Construction Field Report

Lot/Subdivision: 2 SWANWATER
33 Hybrid Lane.

Notes: RE: BUILDING PERMIT REVIEW 1/24/2020.

Permit #SFD2001-0038

Ivercon Construction  
 Oakland Plan  
 Lot 14 Sweetwater  
 Cumberland Co., NC

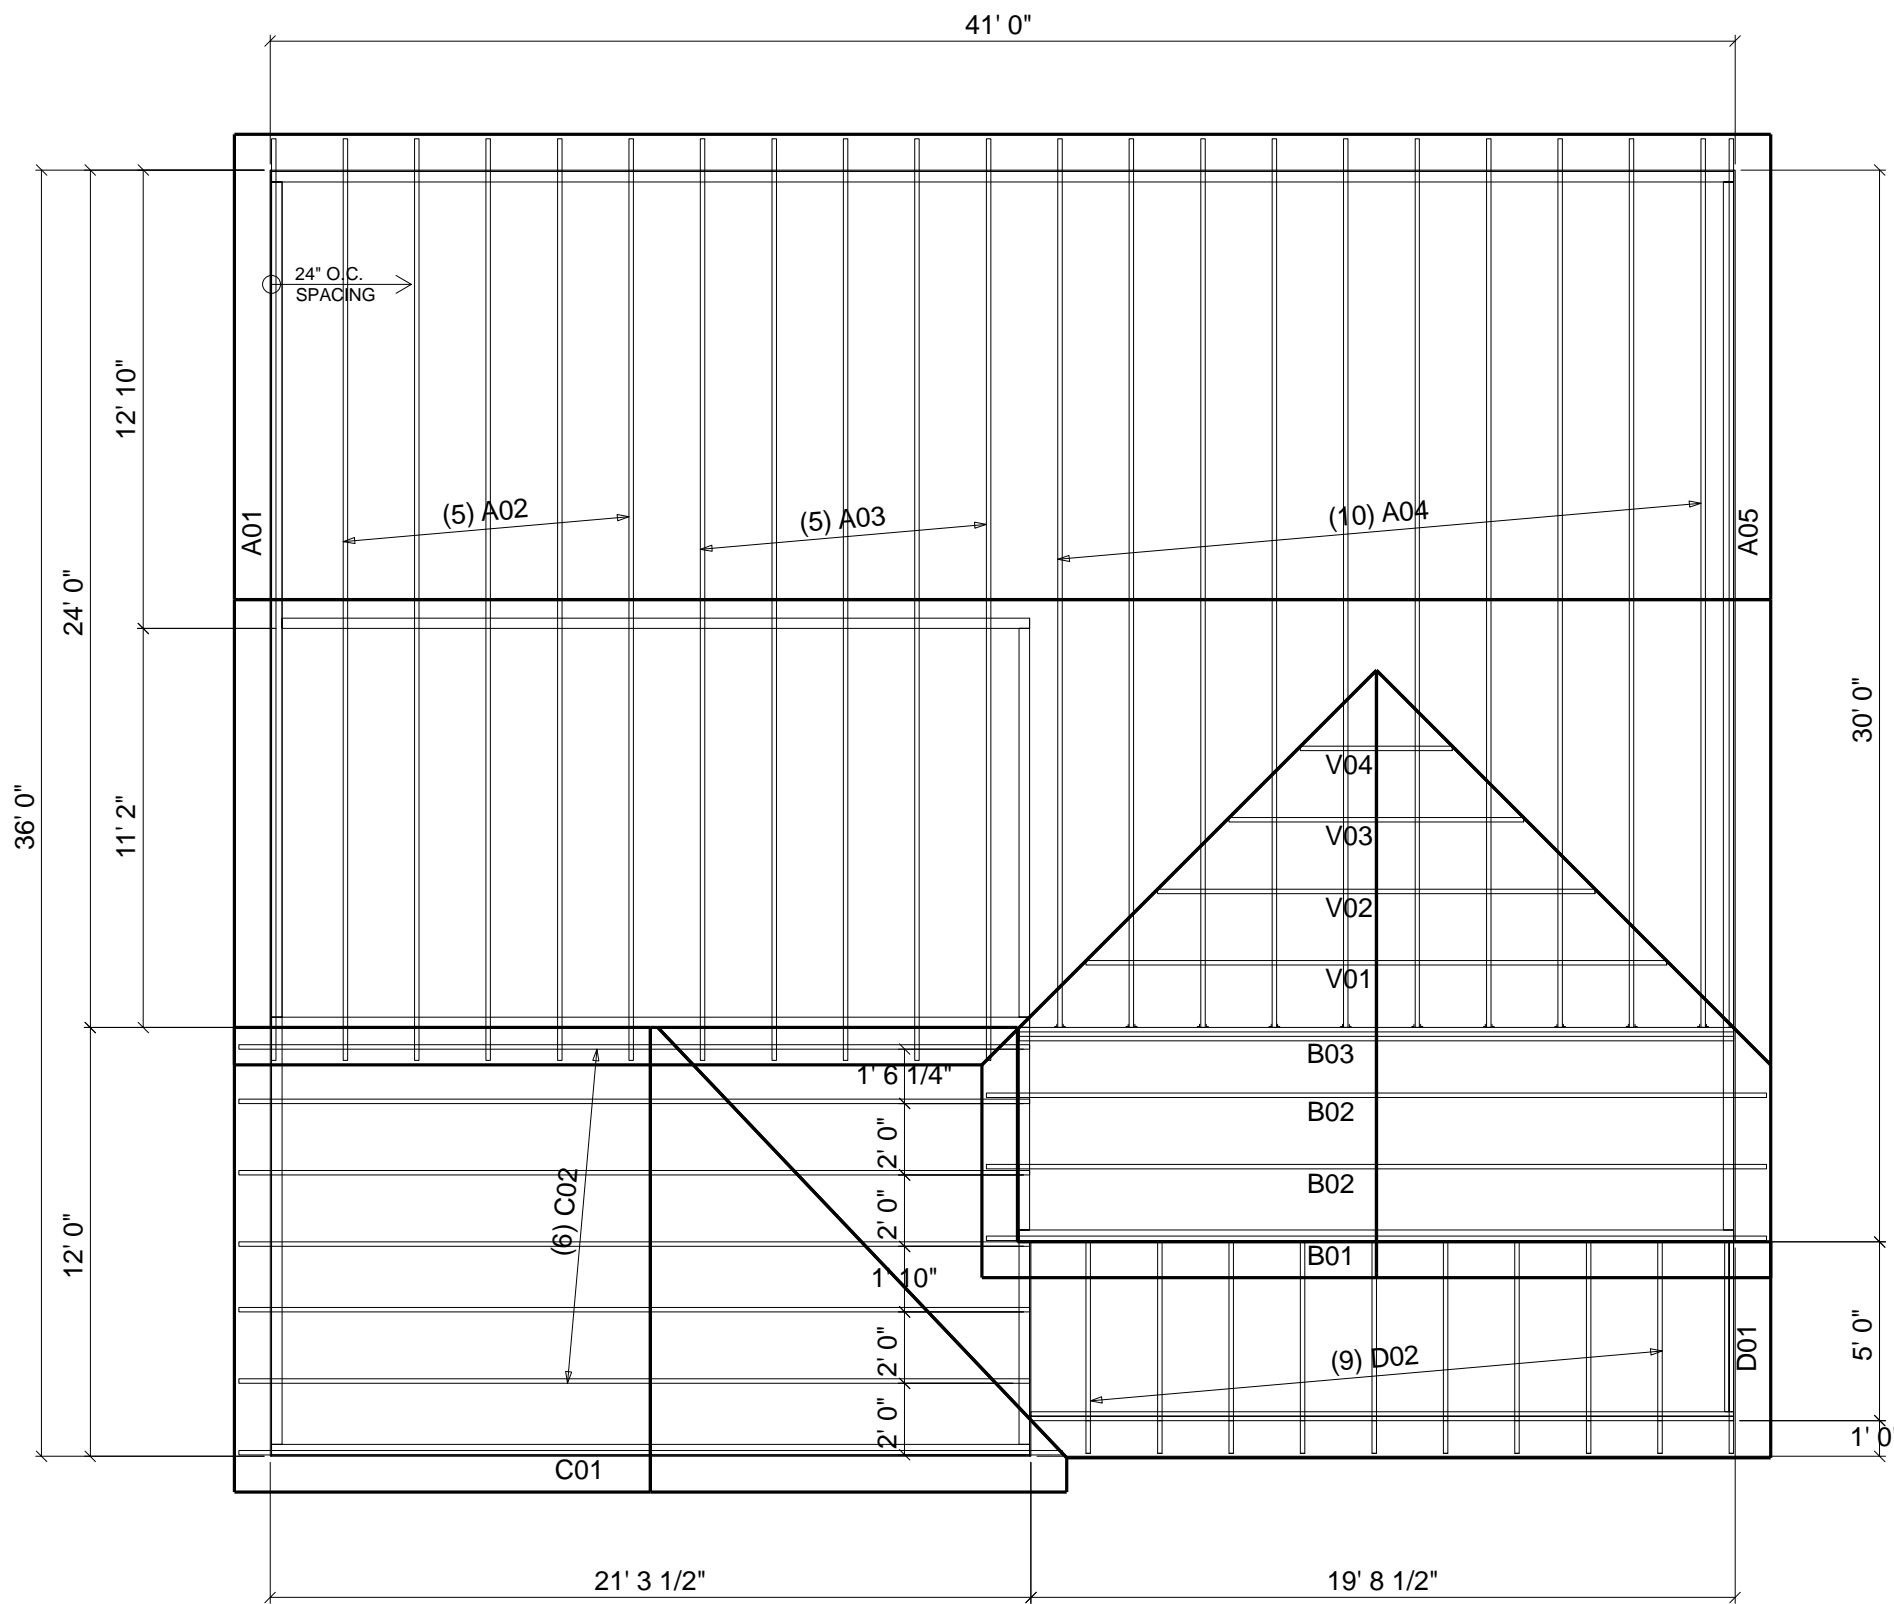
As requested, we are sending the roof truss
layout along with this memo.

Group: AUTO
 Type: RESIDENTIAL BUILDING
 Status: **DISAPPROVED**
 Date Submitted: 1/24/2020
 Date Completed: 2/2/2020
 Reviewer: Brad Sutton
 Notes: 2/2/2020 3:06:14 PM
 Improper footing for beam 1. Need roof truss layout
